SPACE VILLAGE FILING NO. 4

A PORTION OF THE NORTH 1/2 OF SECTION 17, TOWNSHIP 14 SOUTH, RANGE 65 WEST OF THE 6TH PRINCIPAL MERIDIAN,
IN THE COUNTY OF EL PASO, STATE OF COLORADO
SHEET 2 OF 2

| PCD FILING NO. MS-22-007 | | REVISION DESCRIPTION: | | BY: | DATE: |

## PCD FILING NO. MS-22-007

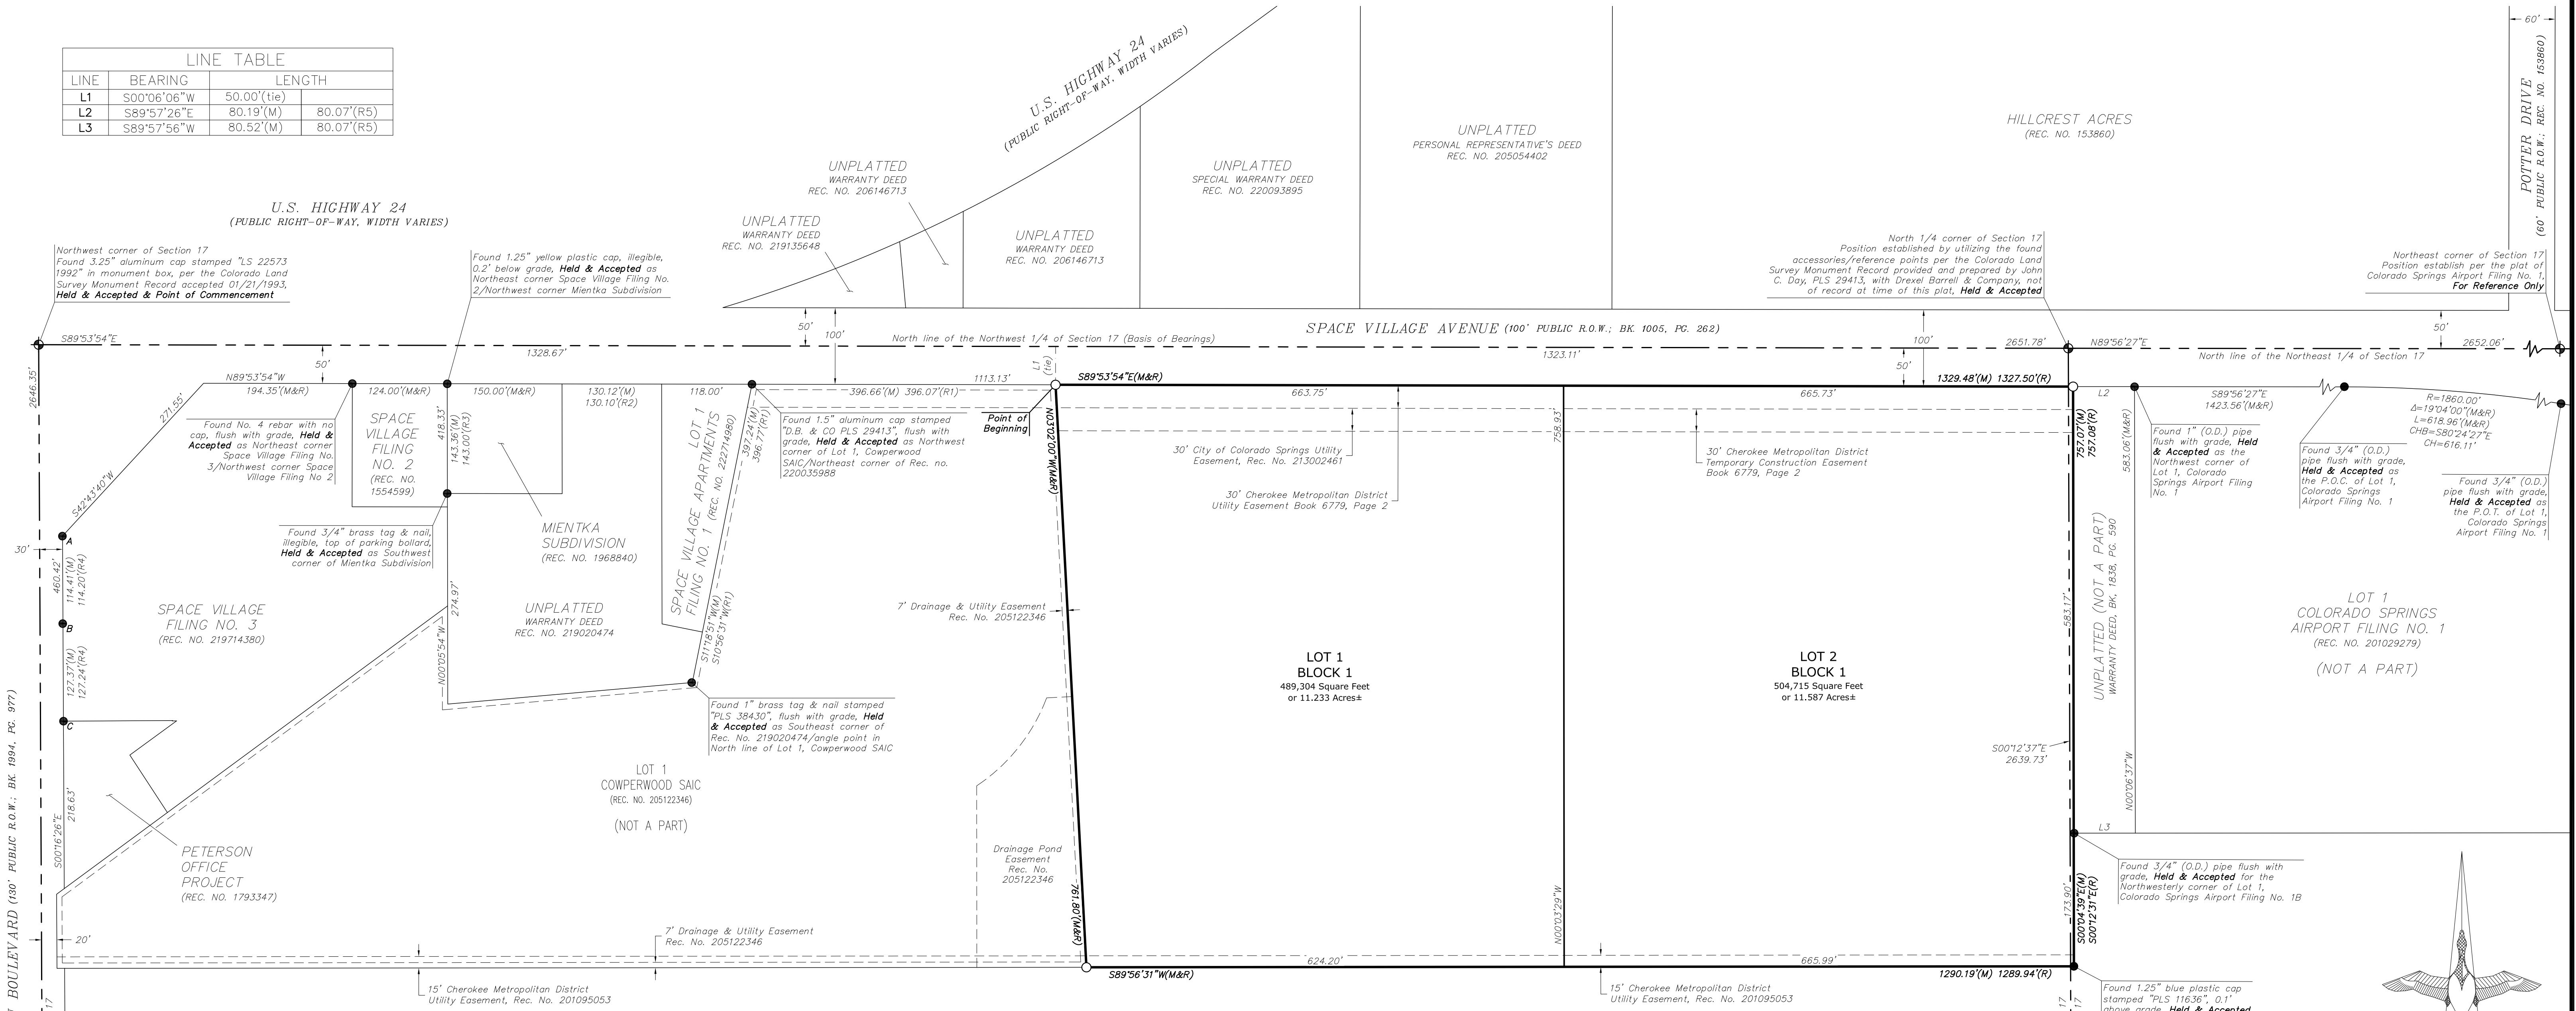
There should be 4 lines, and we will require the book and page reception numbers for each

Provide drainage easement for the proposed swale and channel
Response: Will add the drainage easement(s) to the plat once the line work has been received from engineering.

Response: Will add the drainage easement(s) to the plat once the line work has been received from engineering.
Unresolved Review 1 Comment: Show drainage easements for the proposed ponds and provide recording number.
Provide bearing and distance data of the proposed drainage easement

Response: 1) There are only 3 lines for the line table; 2) For clarity, all of the recording information pertaining to the record bearings & distances are listed under the miscellaneous notes on this sheet, just under the line legend, no changes made.
